Re: Winrock Town Center 2100 Louisiana Blvd. NE

Traffic Circulation LayoutEngineer's/Architect's Stamp 4/20/2025 J19D058

Trans-2025-00155

Based upon the information provided in your submittal received 06/06/2025, the above referenced plan cannot be approved for Building Permit until the following comments are addressed:

DATE: 4/20/2025	SHEET: SP-1
SCALE: RE: SCALE

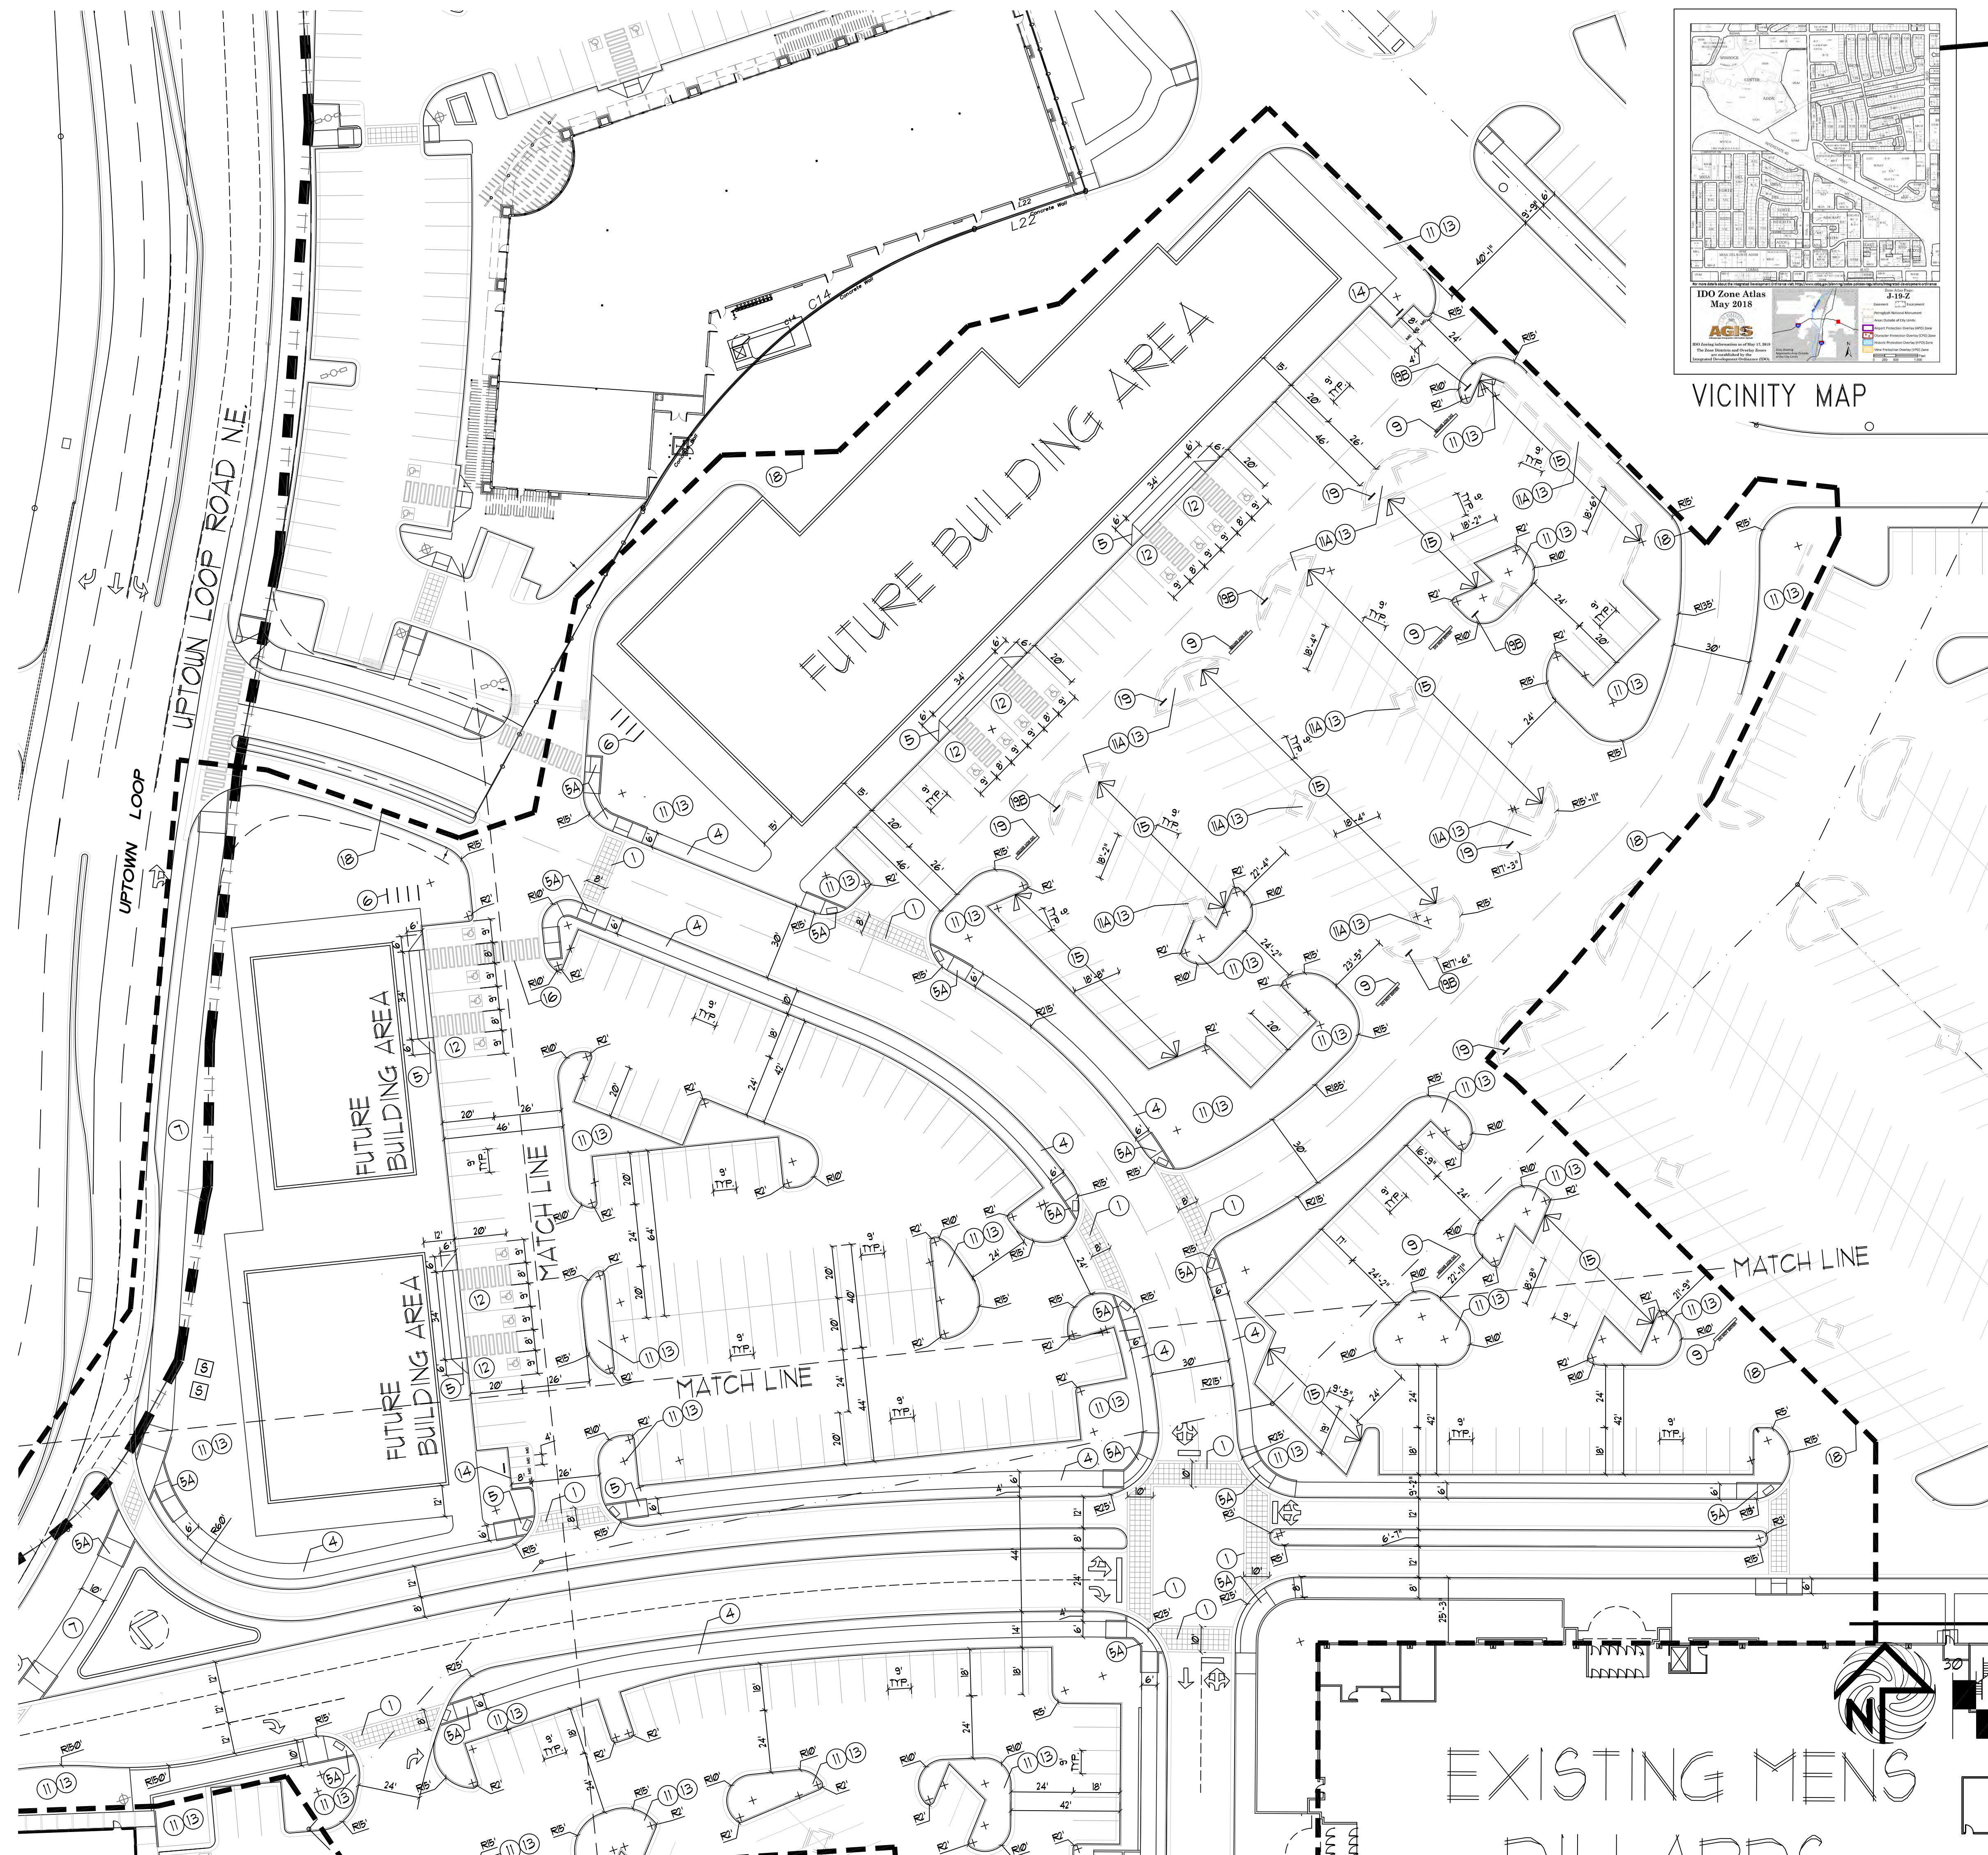
- 3. On the Handicap ramp call out standard and provide dimensions.
- 4. The traffic circulation layout must be stamped, signed, and dated by an engineer or architect licensed in the state of New Mexico.
- 5. Please list the width and length for all existing and proposed parking spaces. Some dimensions are not shown.

- 7. The ADA accessible spaces must include an access aisle. Van accessible aisles should be 8ft wide; all others should be 5ft wide.
- 8. The ADA accessible parking sign must have the required language per 66-7-352.4C NMSA 1978 "Violators Are Subject to a Fine and/or Towing." Please call out detail and location of signs.

- 11. Motorcycle parking spaces shall be designated by its own conspicuously posted upright sign, either free-standing or wall mounted per the zoning code.
- 12. All bicycle racks shall be designed according to the following guidelines:

- a. The rack shall be a minimum 30 inches tall and 18 inches wide.
- The bicycle frame shall be supported horizontally at two or more places.
 Comb/toaster racks are not allowed.
- 13. Show all drive aisle widths and radii. Some dimensions are not shown.
- 14. List radii for all curves shown; for passenger vehicles. Radius for delivery trucks, fire trucks, etc. is 25 ft. or larger.
- 15. A 5 ft. keyway is required for dead-end parking aisles.
- 16. Per the DPM, a 6 ft. wide ADA accessible pedestrian pathway is required from the public sidewalk to the building entrances. Please clearly show this pathway and provide details.
- 17. Per DPM, a 6 ft. wide ADA accessible pedestrian pathway is required from the ADA parking stall access aisles to the building entrances. Please clearly show this pathway and provide details.

18. All one-way drives shall have "One Way" and "Do Not Enter" signage and pavement markings. Please show detail and location of posted signs and striping.
